File: SF15/20035
Job ID No: DOC15/520531
Your Ref: SSD7056

RE: Exhibition of State Significant Development for Remediation, Restoration and Adaptive Re-Use of Campbell's Stores, 7-27 Circular Quay West, The Rocks (SSD 7056)

The Heritage Council Approvals Committee considered the matter at its meeting on 3 February 2016 and resolved to recommend the following conditions of consent:

03 HICKSON ROAD / SOUTH-WEST ELEVATION
SCALE 1:50

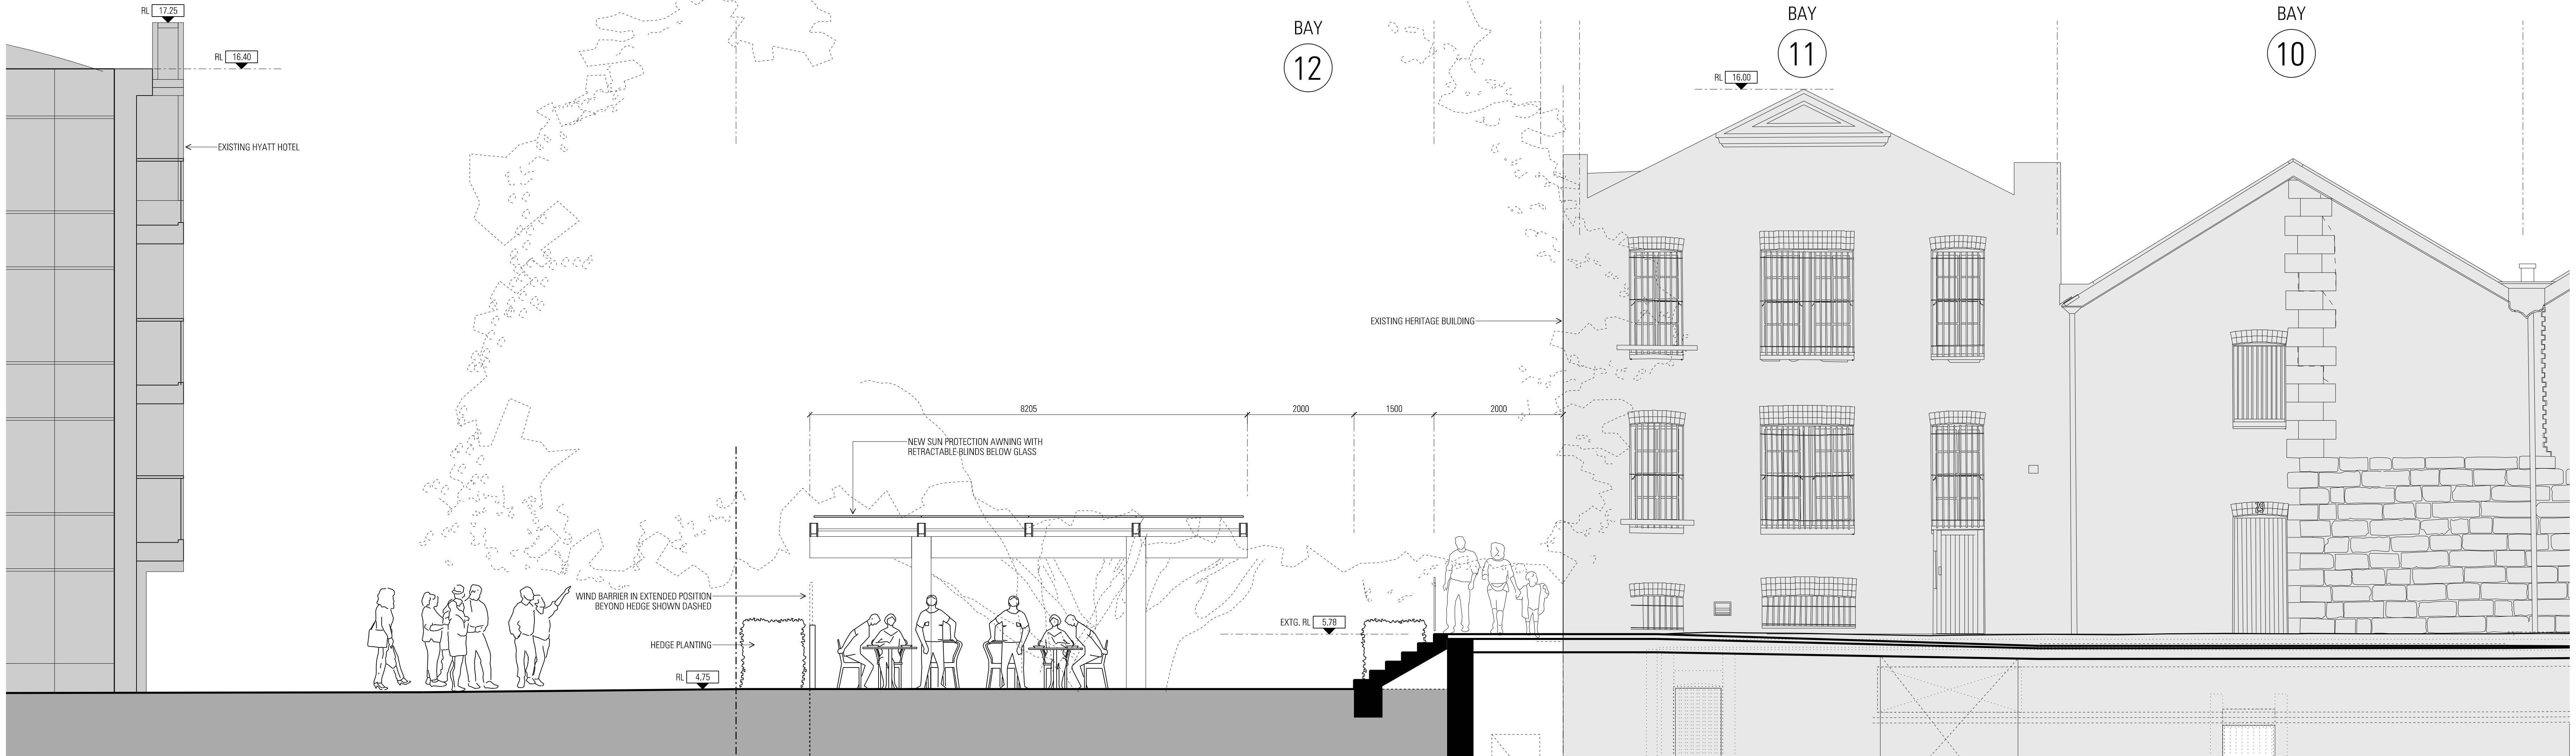
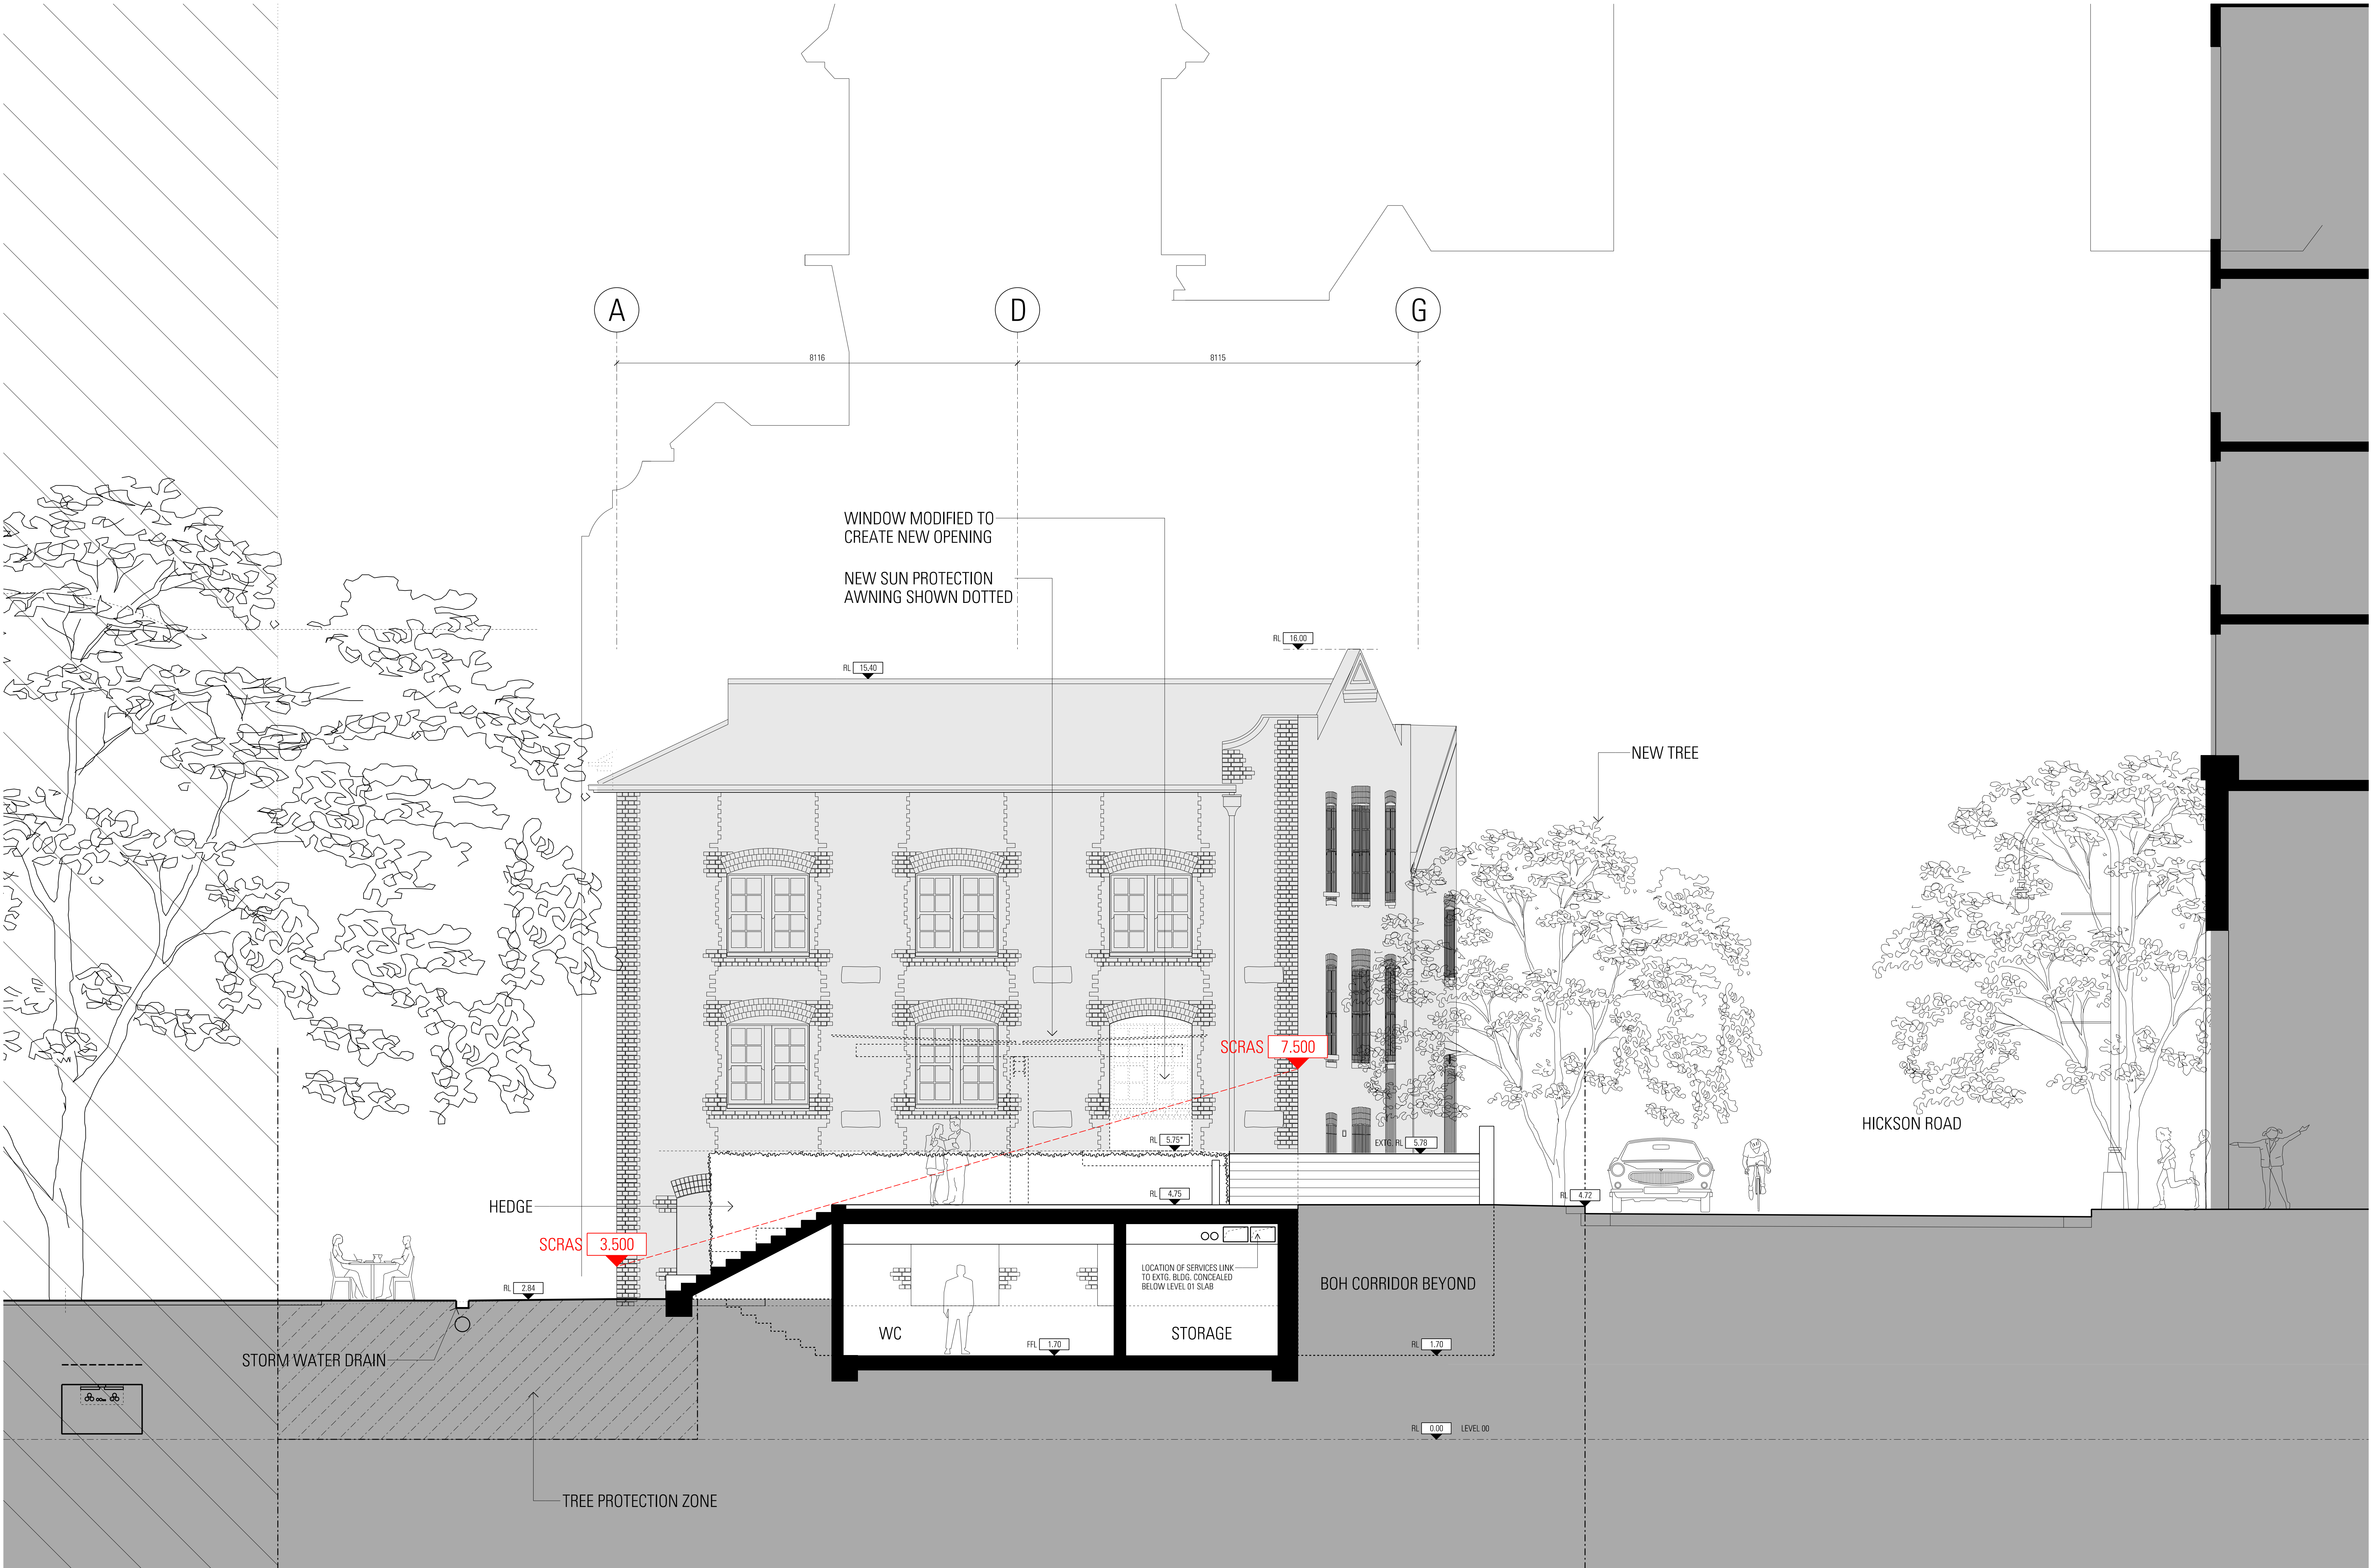
1. The new doorways in Bays 3, 6 and 9 of the west façade propose the removal of significant fabric and addition of new contemporary awnings in three locations that would diminish the architectural character of the west façade from Hickson Road to an unacceptable level. It is recommended that approval is granted to Bay 6 only as this is the public bay and would be symmetrically placed.
